OUT16/43396

**Haerses Road Sand Quarry Modification 1 (DA 165-7-2005 MOD 1)
Comment on the Environmental Assessment**

DPI has reviewed the Environmental Assessment and provides the following comments, recommendations and advice:

Figure 10: Proposed MTSGS buffer zone and maximum extraction depths

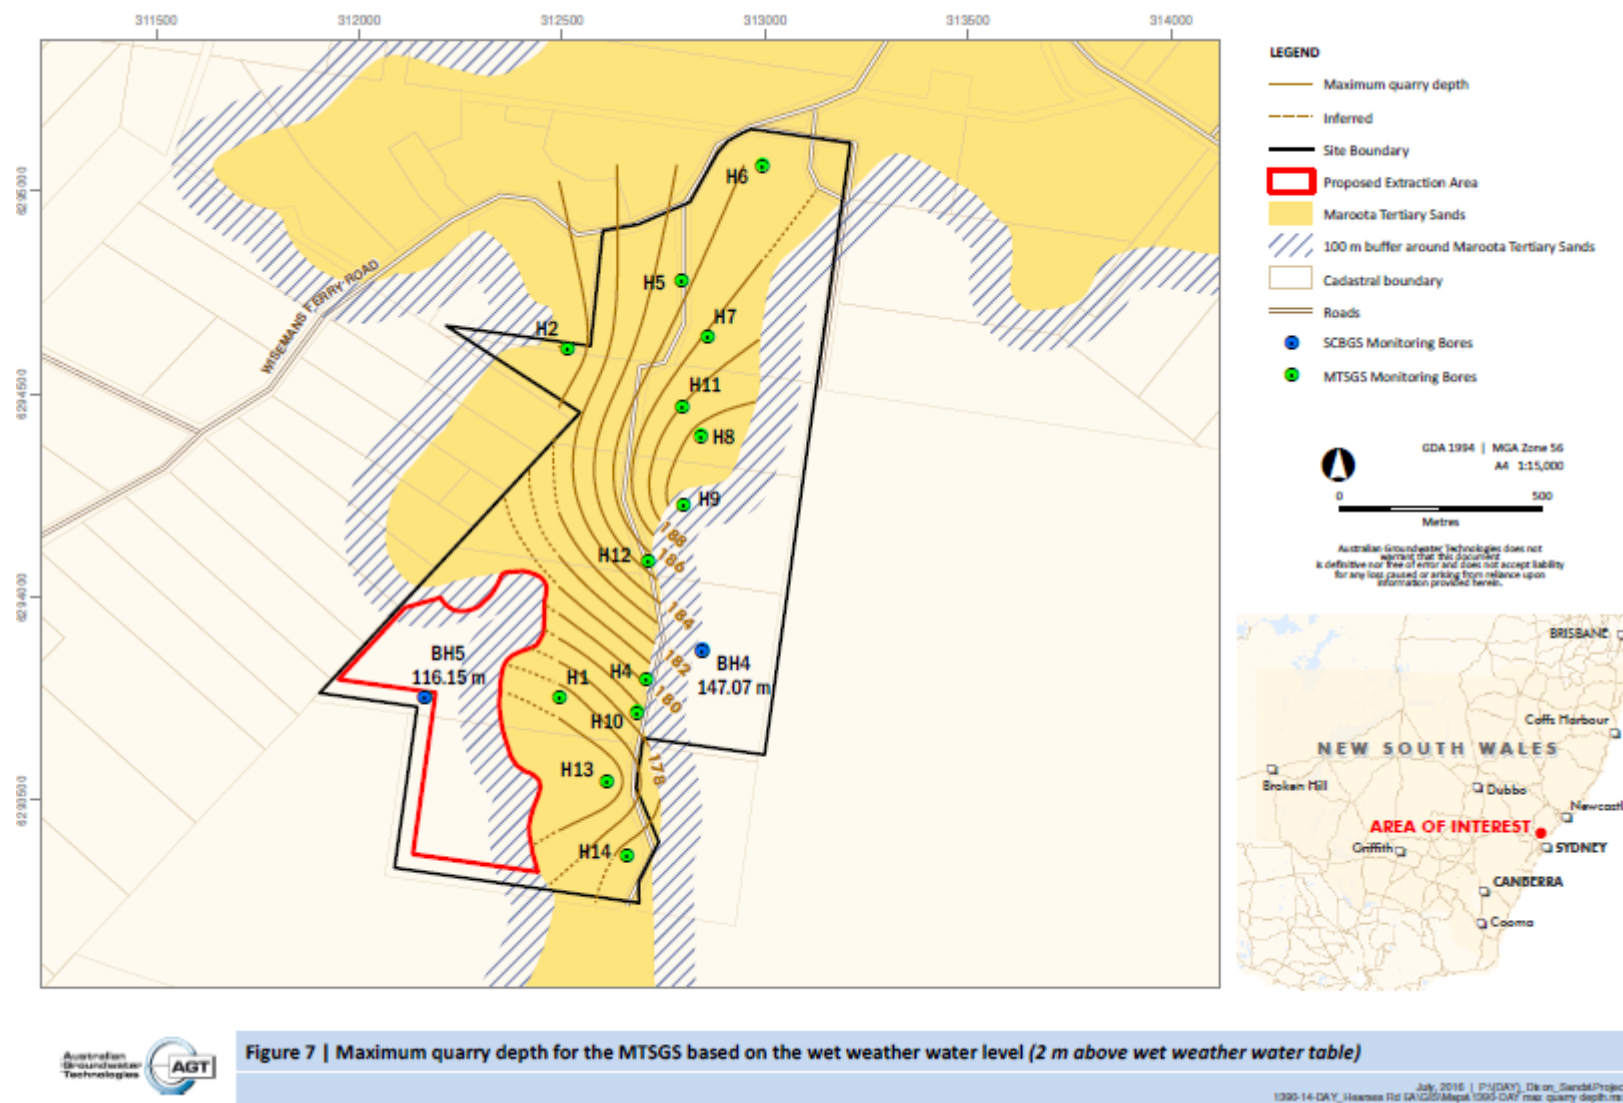
- While the EIS indicates that groundwater will not be encountered during excavation for the project, DPI does not consider that this has been adequately established. Due to the topography of the surrounding area, and the uncertainty surrounding the hydrogeology, there is a risk that if groundwater is encountered this could lead to leakage of groundwater from the Maroota Tertiary Aquifer with potential flow on effects to the environment and other land users.

- The proponent should provide further detail on staged development with progressive quarrying of cells as proposed to include staging of depth of excavation. The intent being to monitor for the presence of groundwater at increasing depths of excavation. The Trigger Action Response Plan should provide for a cease mining condition, should groundwater be encountered, with a requirement for consultation with DPI Water hydrogeologists before continuing work.

- Conditions of consent should prohibit interception of groundwater, and require immediate cessation of operations if groundwater is encountered. Alternatively, the proponent should undertake additional investigations as outlined below.
